SILVERADO RANCH FILING NO. 1 Construction Drawings El Paso County, Colorado

SILVERADO RANCH FILING NO. 1

MASTER GRADING PLAN

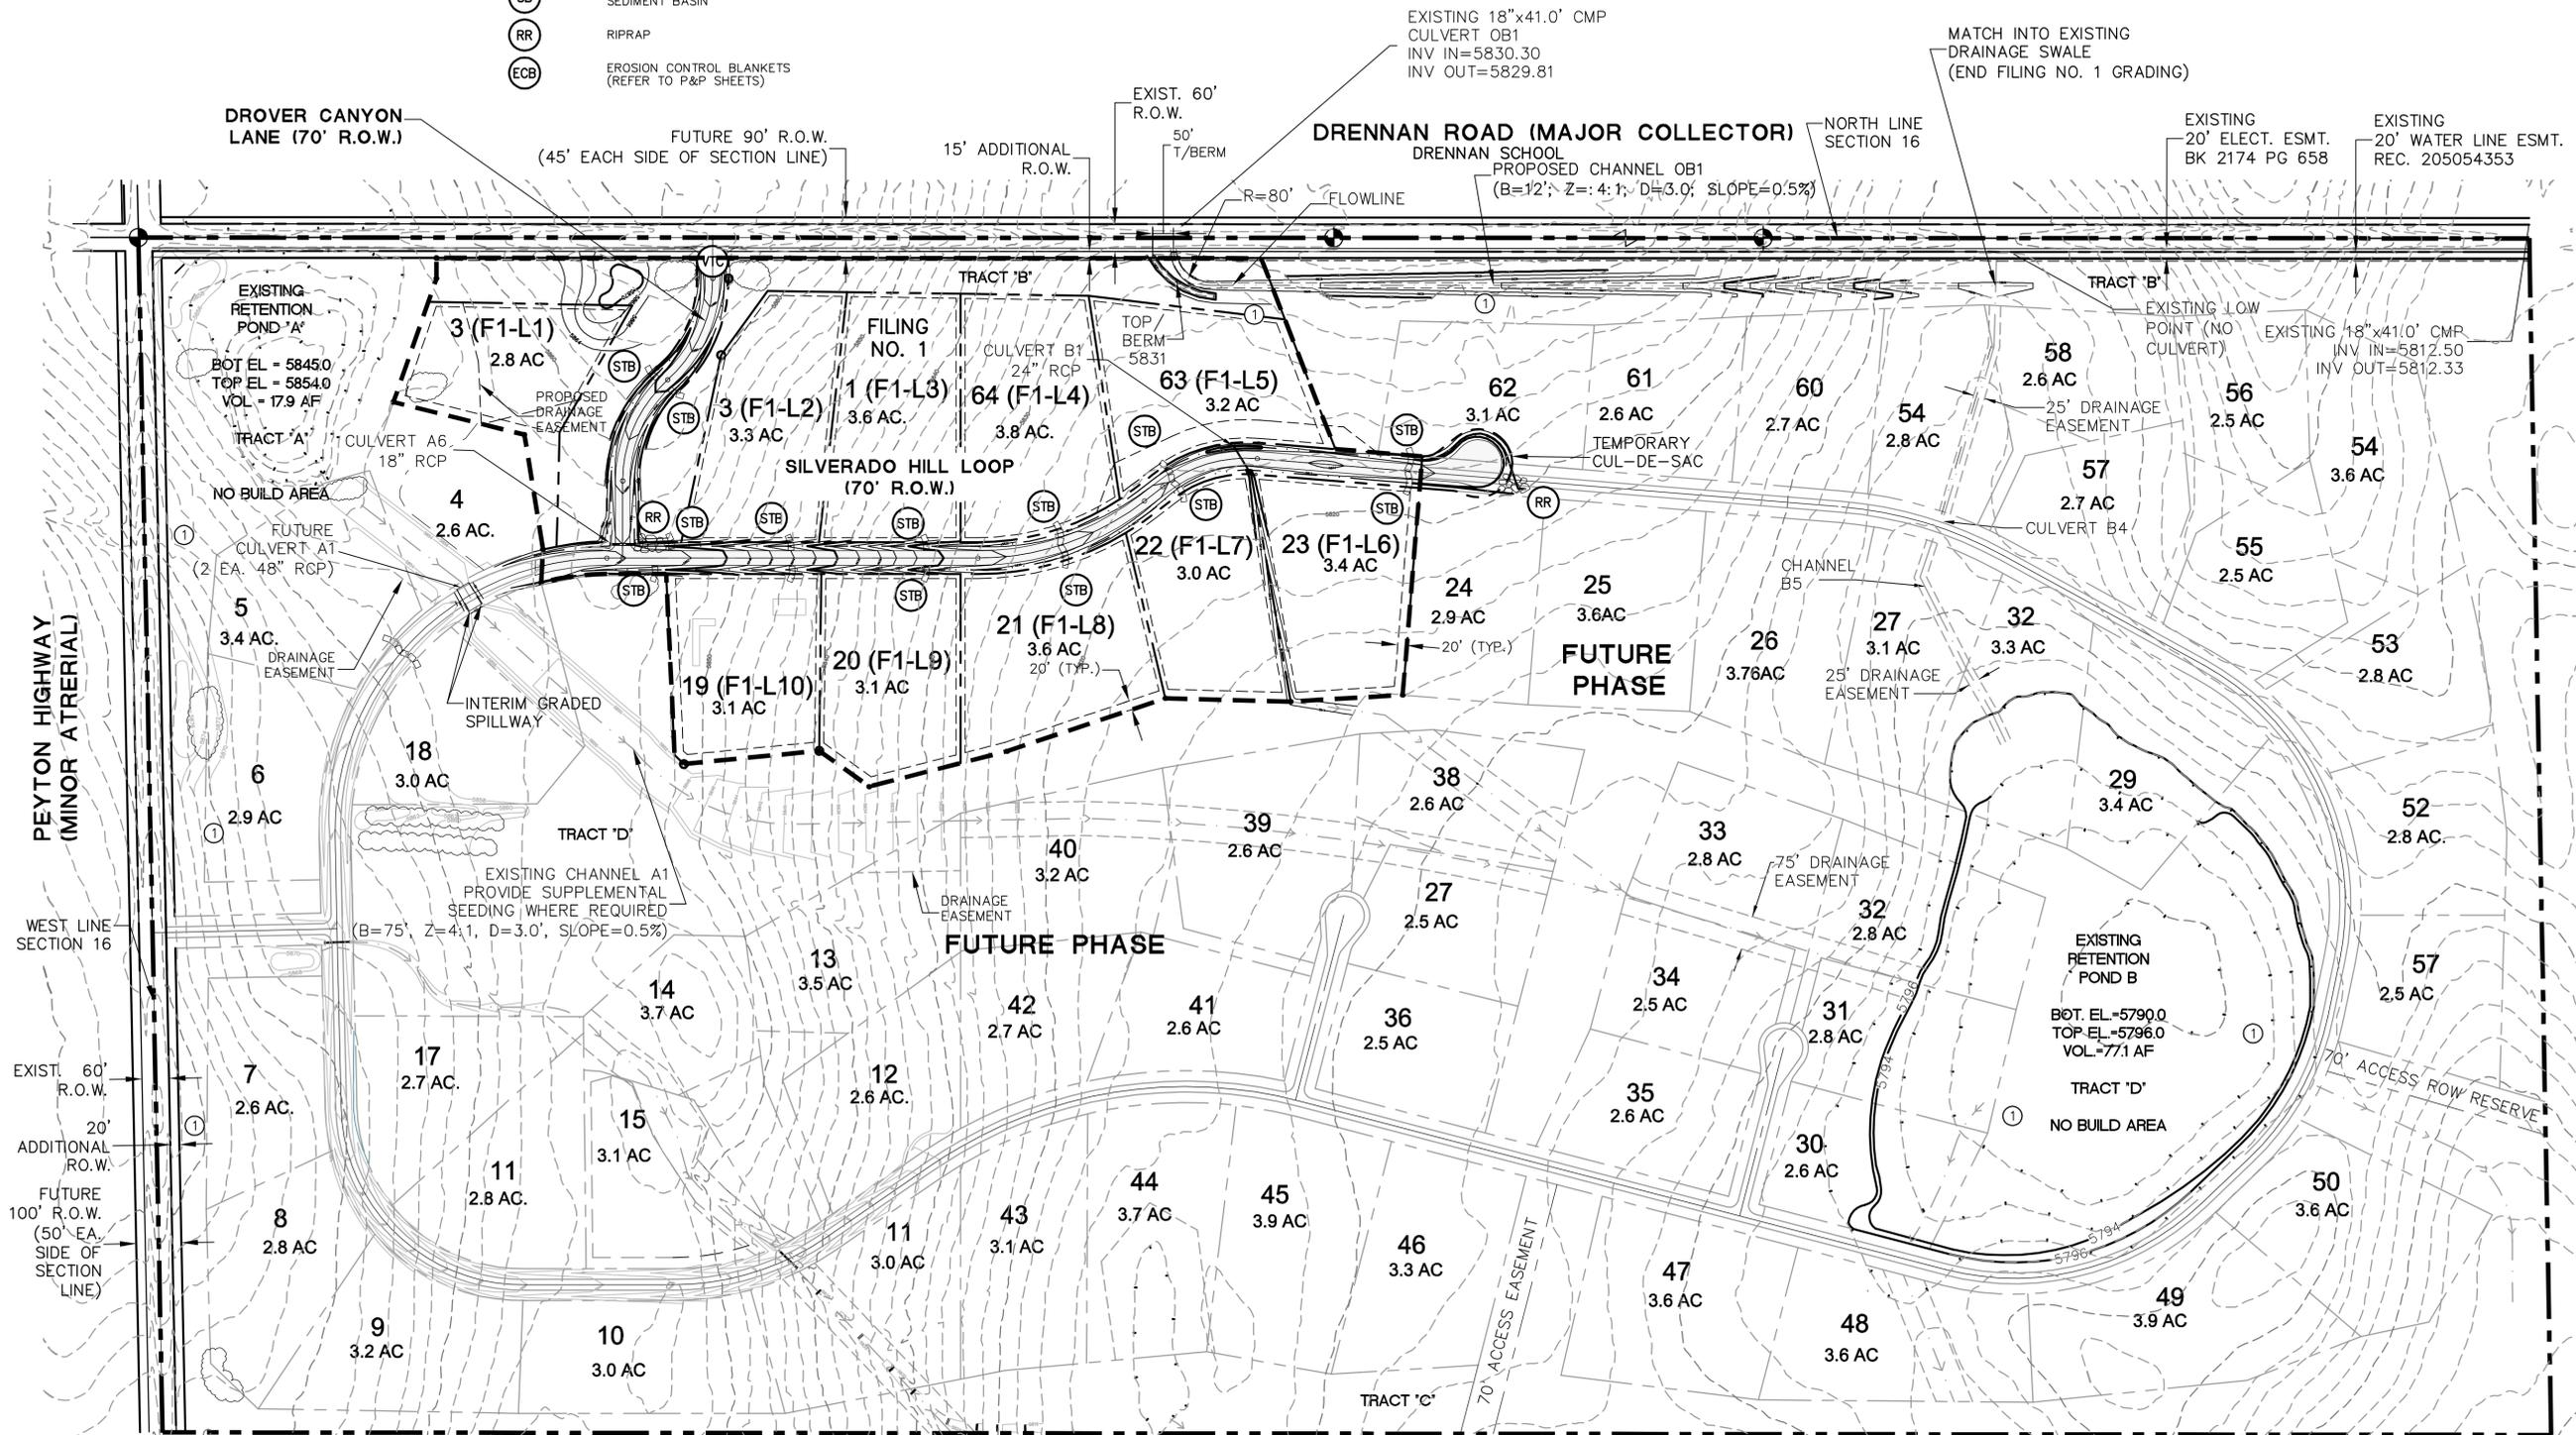
Provide limits of construction, limits of disturbance

include in LOC/LOD

If the pond is being expanded with Filing 1, include in LOC and LOD.
